## Inspector's Report

### ABP-321255-24

<b>Development</b>	Ballinclare Quarry, Proposed Material Recovery / Recycling Facility and Inert Landfill
<b>Location</b>	In the townlands of Ballinclare and Carrigmore, near Kilbride, Co. Wicklow
<b>Planning Authority</b>	Wicklow County Council
<b>Applicant(s)</b>	Kilsaran Concrete Unlimited Company
<b>Type of Application</b>	Application for approval Permission under 37E of the Planning and Development Act 2000, as amended
<b>Prescribed Bodies</b>	Development Applications Unit. Eastern Midlands Connacht Ulster and Southern Regional Waste Management Planning Offices. Geological Survey of Ireland. Health Services Executive.

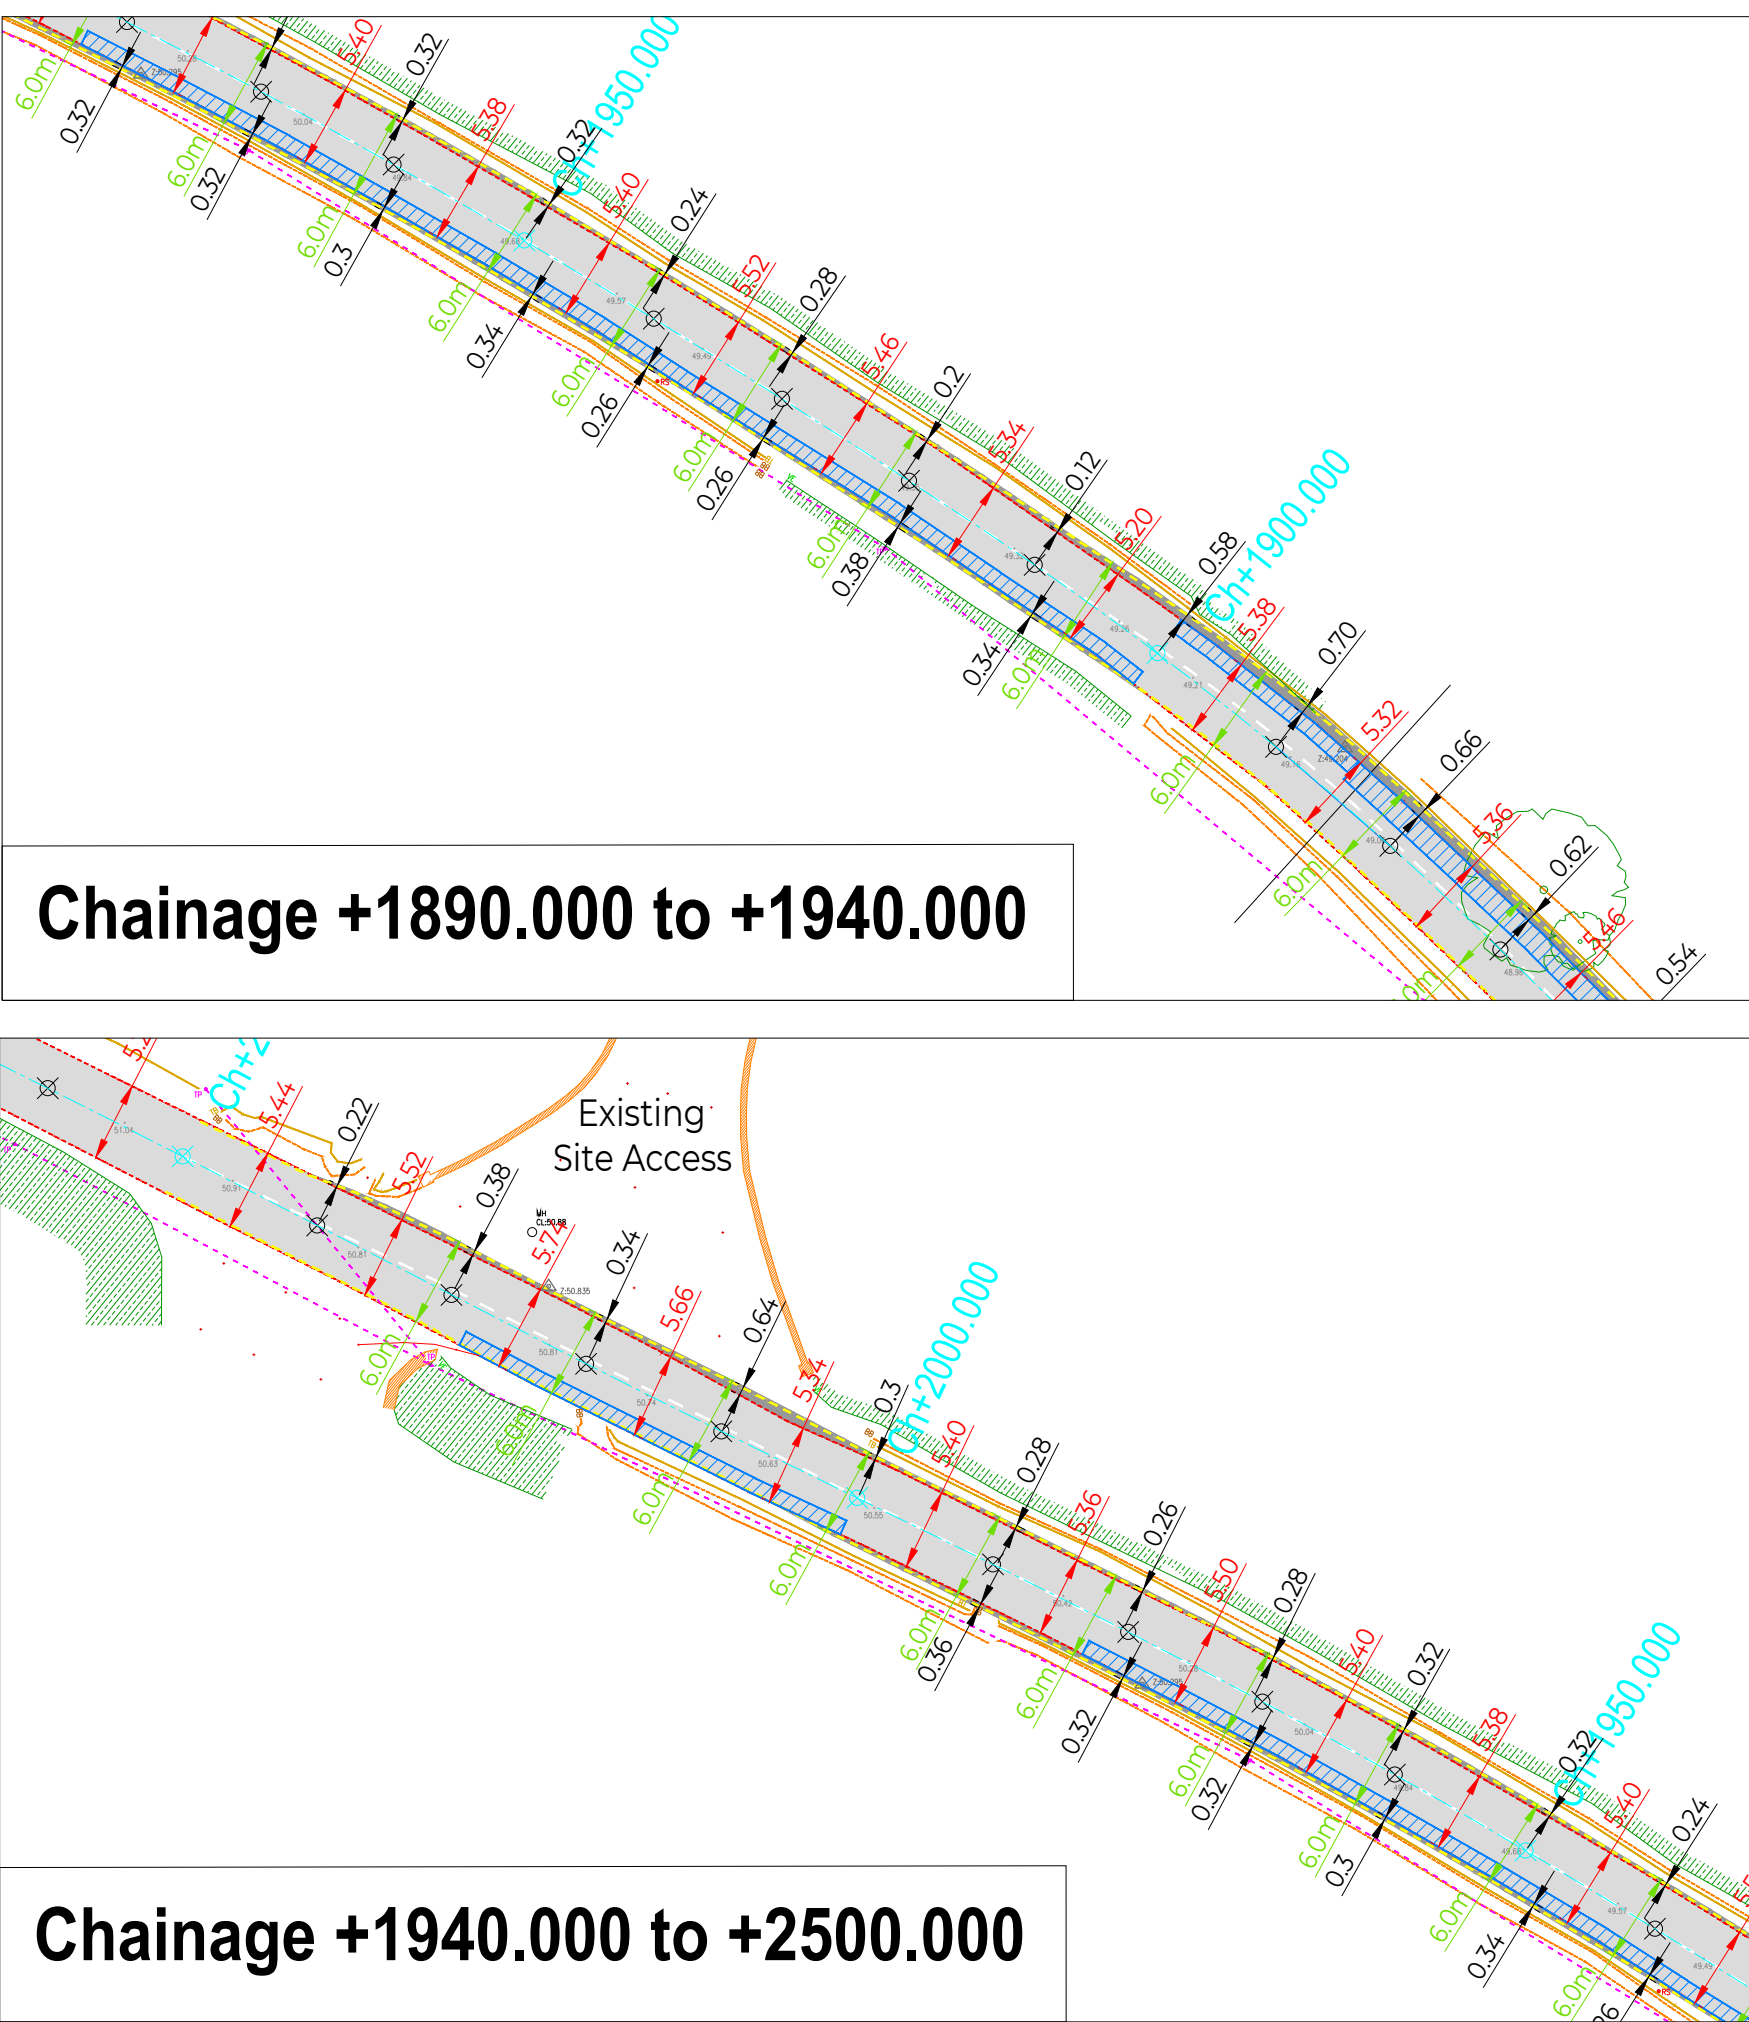
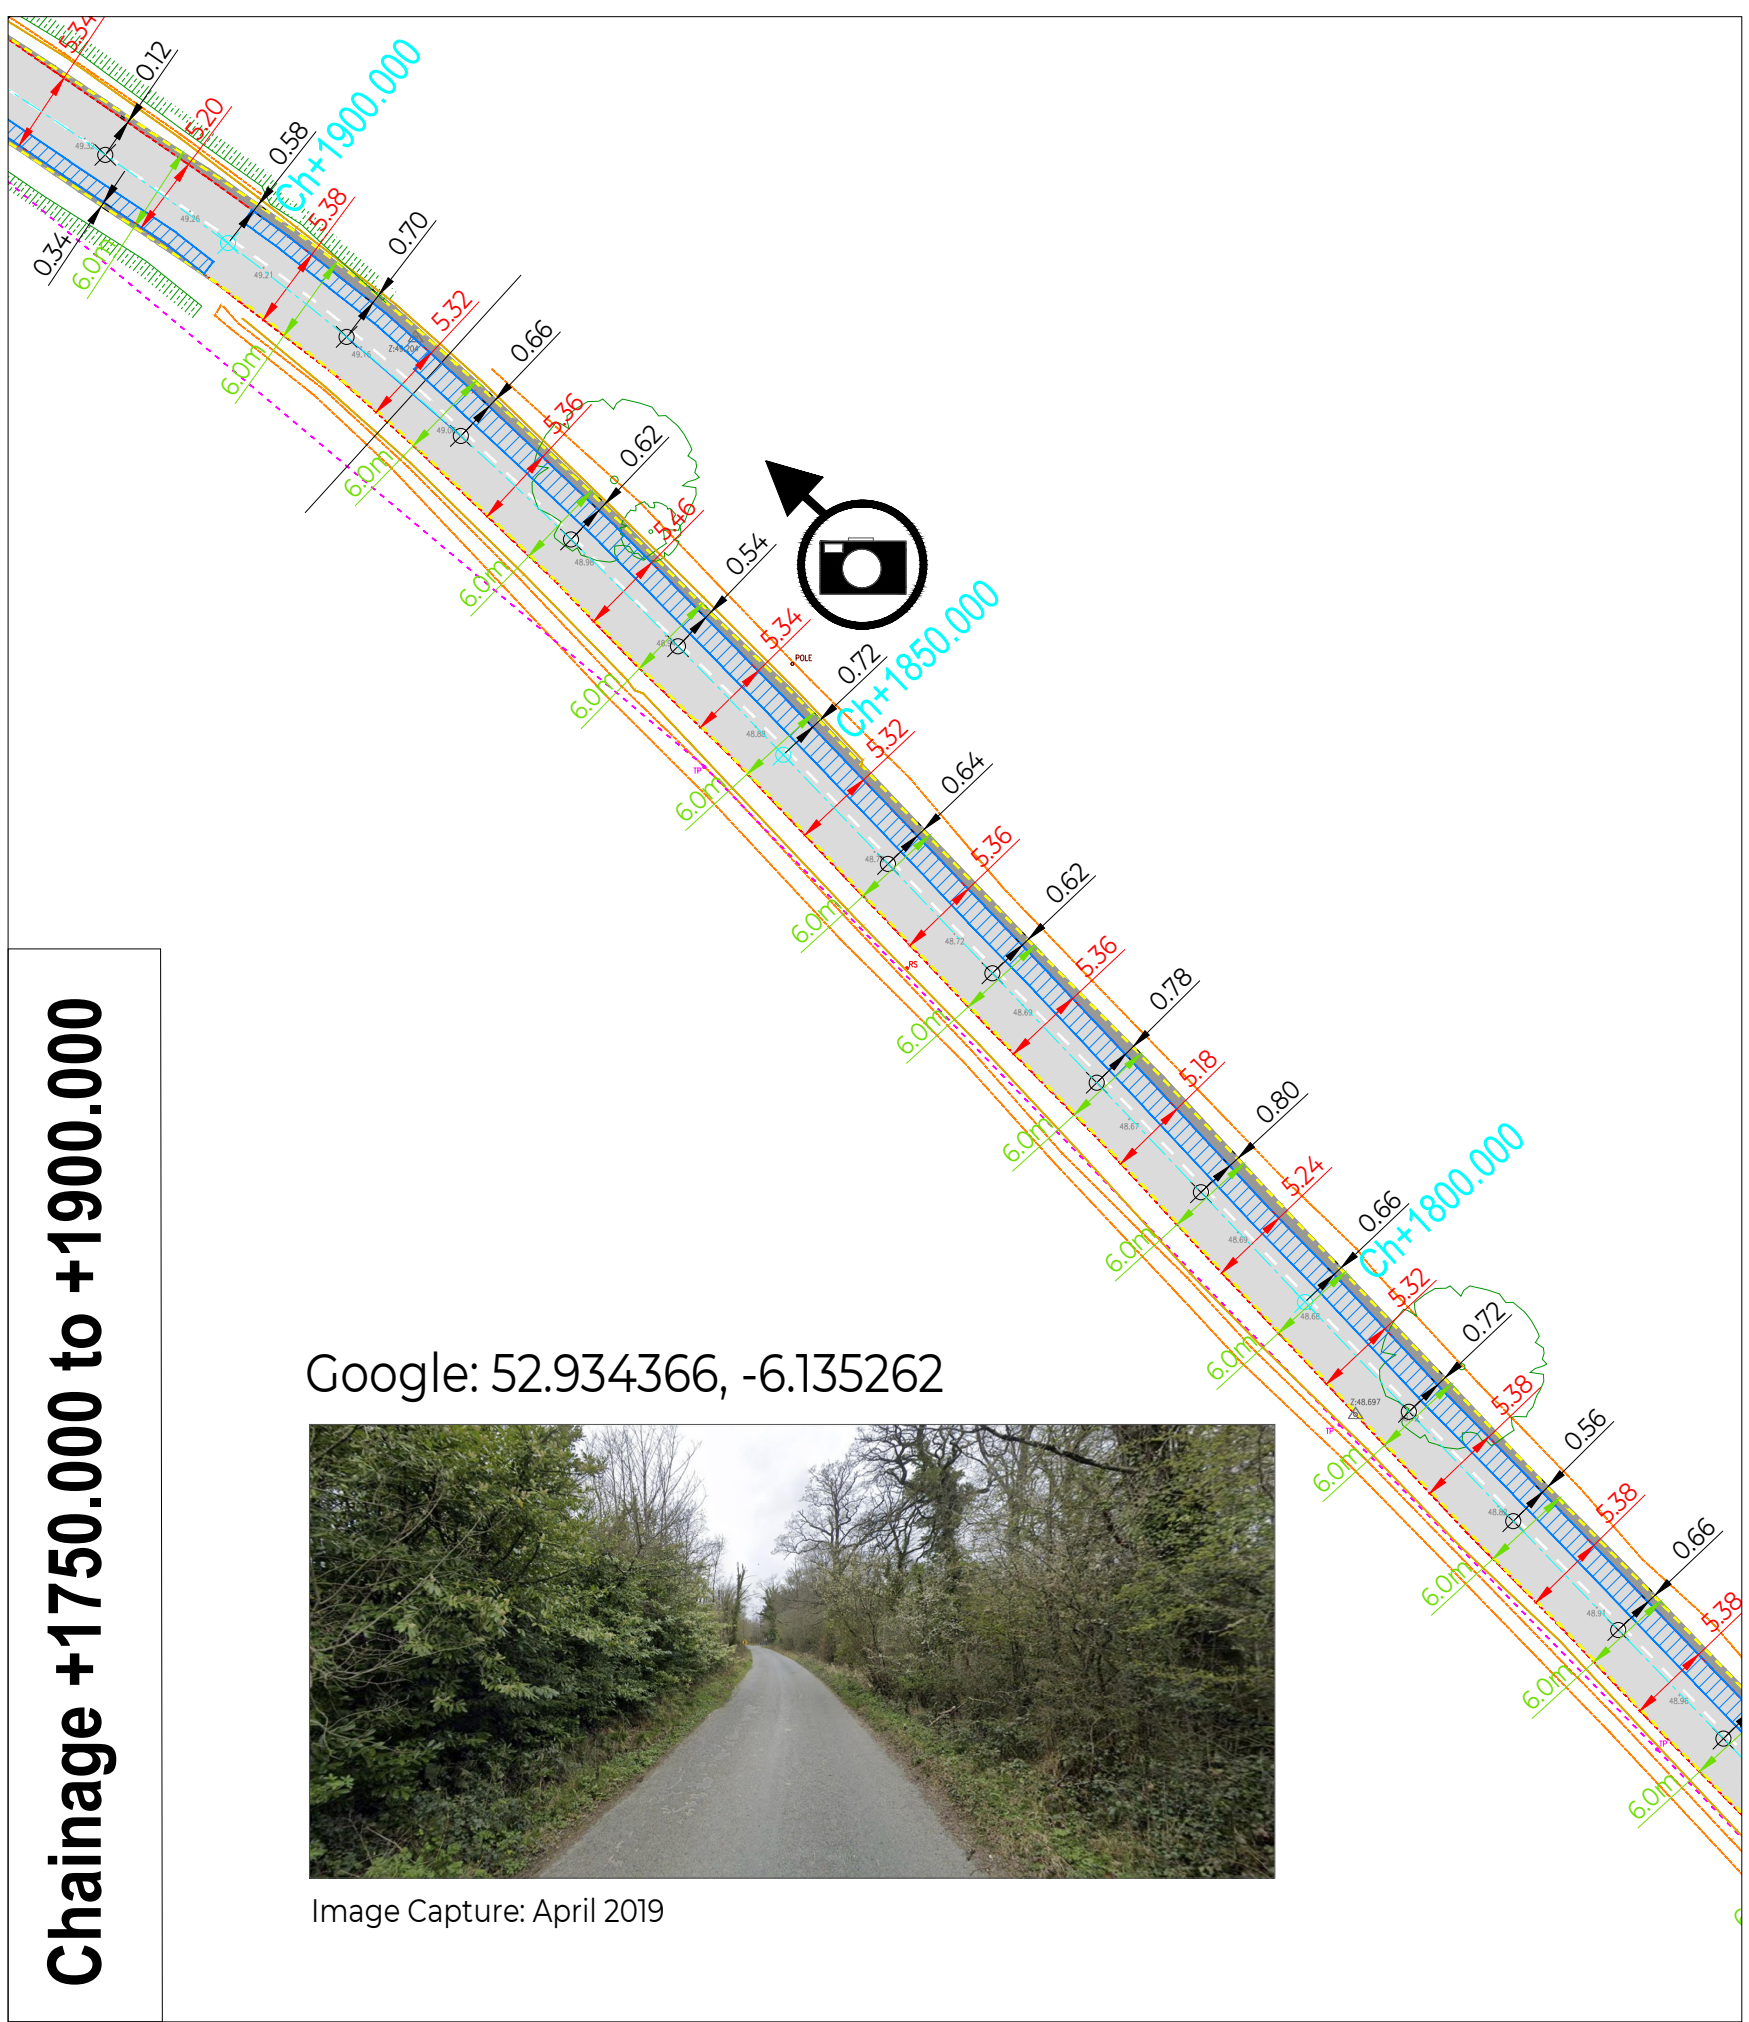
- Recommend a condition that the developer submit appropriate plans and details for the proposed road strengthening works on Local Road L1157 associated with M11 overpass 'Eirspan Structure no: BM-M11-046.00.' The plans and details shall demonstrate compliance with TII Publications and shall also ensure the 5.3m clearance shall be maintained over the extents of the new road layout on the Local Road L1157.
